DOC20/905735

2 November 2020

**St Marys Intermodal – Modification 1 –
Rail Siding Refurbishment Works Package (SSD 7308 Mod 1)
Advice on Modification**

Figure 5 | Rail refurbishment works engineering drawings – Sheet 01 of 05 (Source: Applicant's Modification Report)

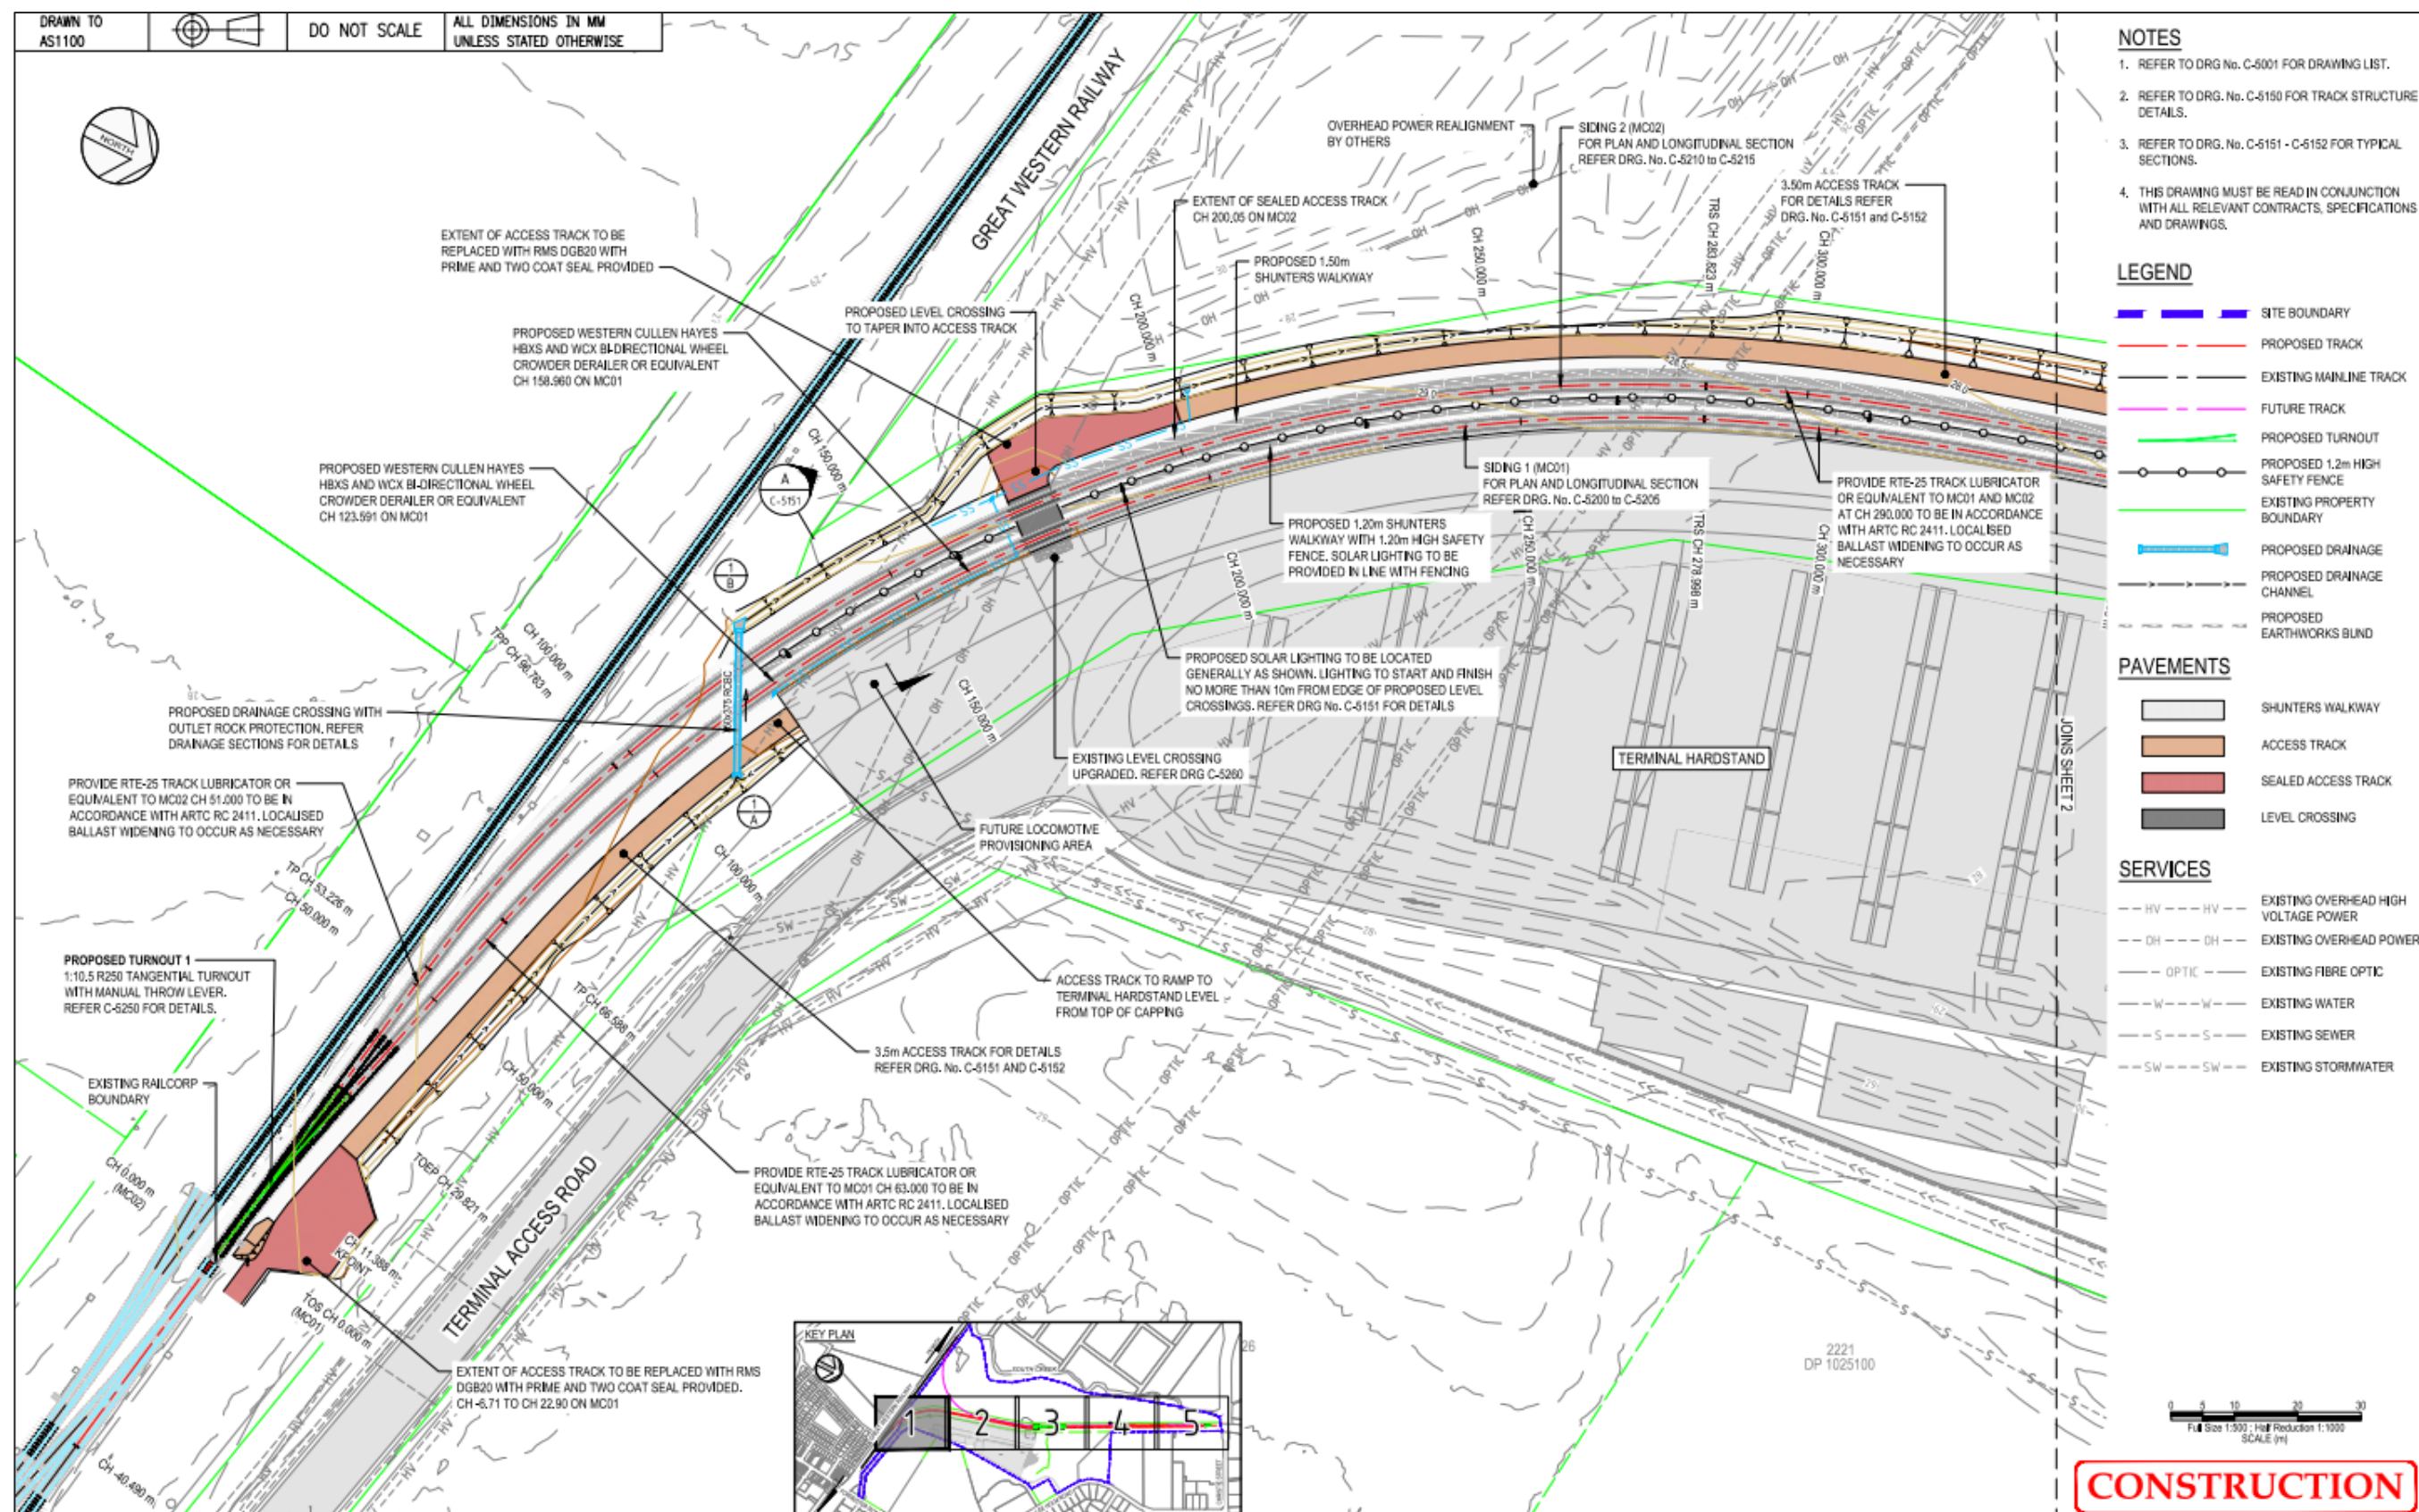
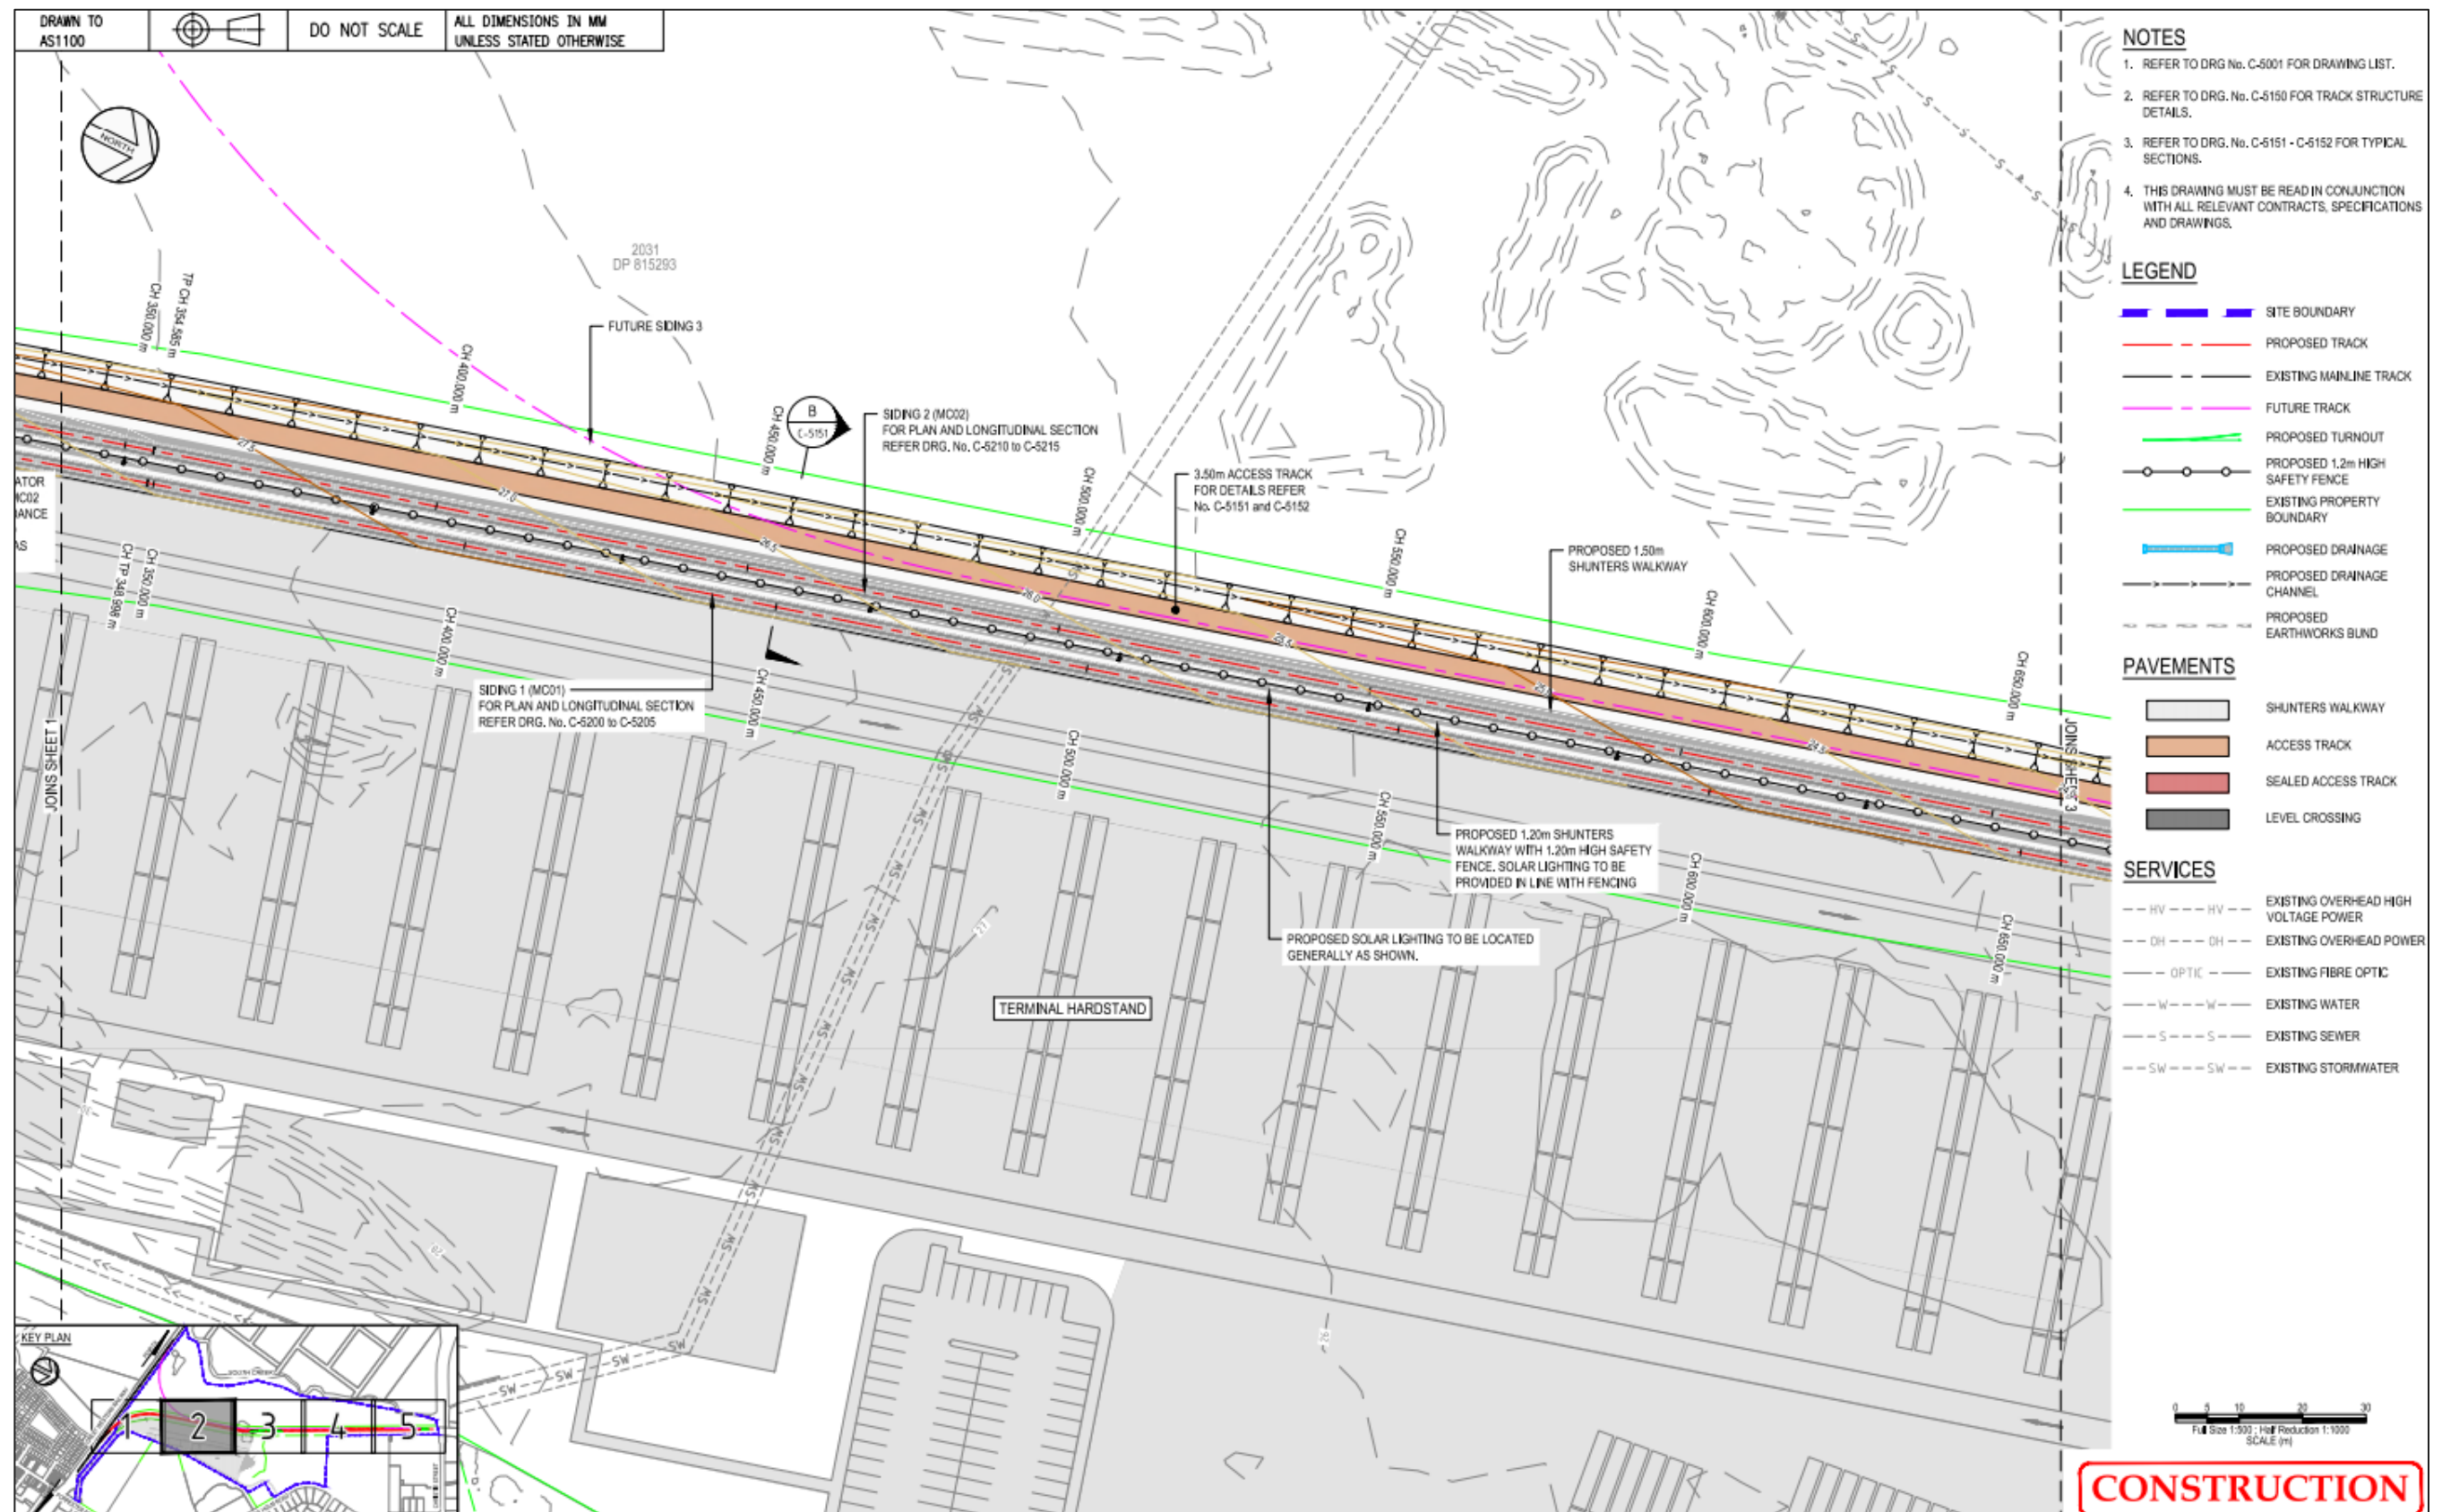
It appears that in the updated NIA, the section of the rail siding which extends north of the area considered in the EIS has been assessed using the provisions from the *Rail Infrastructure Noise Guideline* (EPA, 2013) (RING) for non-network rail lines.

However, it appears that siding will be used for shunting, switching and storage of trains as part of the intermodal facility and does not lead to other industrial premises. As such the EPA considers that the siding sections north of the intermodal are part of the industrial premises and should be assessed using the *Noise Policy for Industry* (EPA, 2017) (NPfI)

Appendix 3 of the RING states: *“Where a non-network rail line exclusively servicing one or more industrial sites extends beyond the boundary of the industrial premises, noise from this section of track should be assessed against the recommended acceptable LAeq noise levels from industrial noise sources for the relevant receiver type and indicative noise amenity area...”*

This was developed for situations where rail activities between the development site and the connection to a network line would be a discrete activity. In this instance, as described above, the sections of rail sidings north of the intermodal is not considered a discrete activity, but rather part of the industrial activities at the intermodal. Therefore, activities that occur on this section of the siding such as shunting, switching or storage should be considered part of the industrial activity at the premises and assessed using the NPfl in conjunction with all other operational noise sources.

The EPA recommends that sections of the siding north of the intermodal should be assessed in accordance with the *Noise Policy for Industry* (EPA, 2017) in conjunction with all other operational activities on the premises.

The original EIS noise impact assessment did not assess rail refurbishment of the whole length of the siding which is proposed to be refurbished in this modification. As such, the construction impacts presented in the modification documents do not appear to consider potential impacts generated by rail refurbishment in the areas proposed in this modification.

The EPA recommends that construction noise and vibration impacts generated by this proposal – that were not considered in the original EIS or other modifications – be assessed as part of this modification.
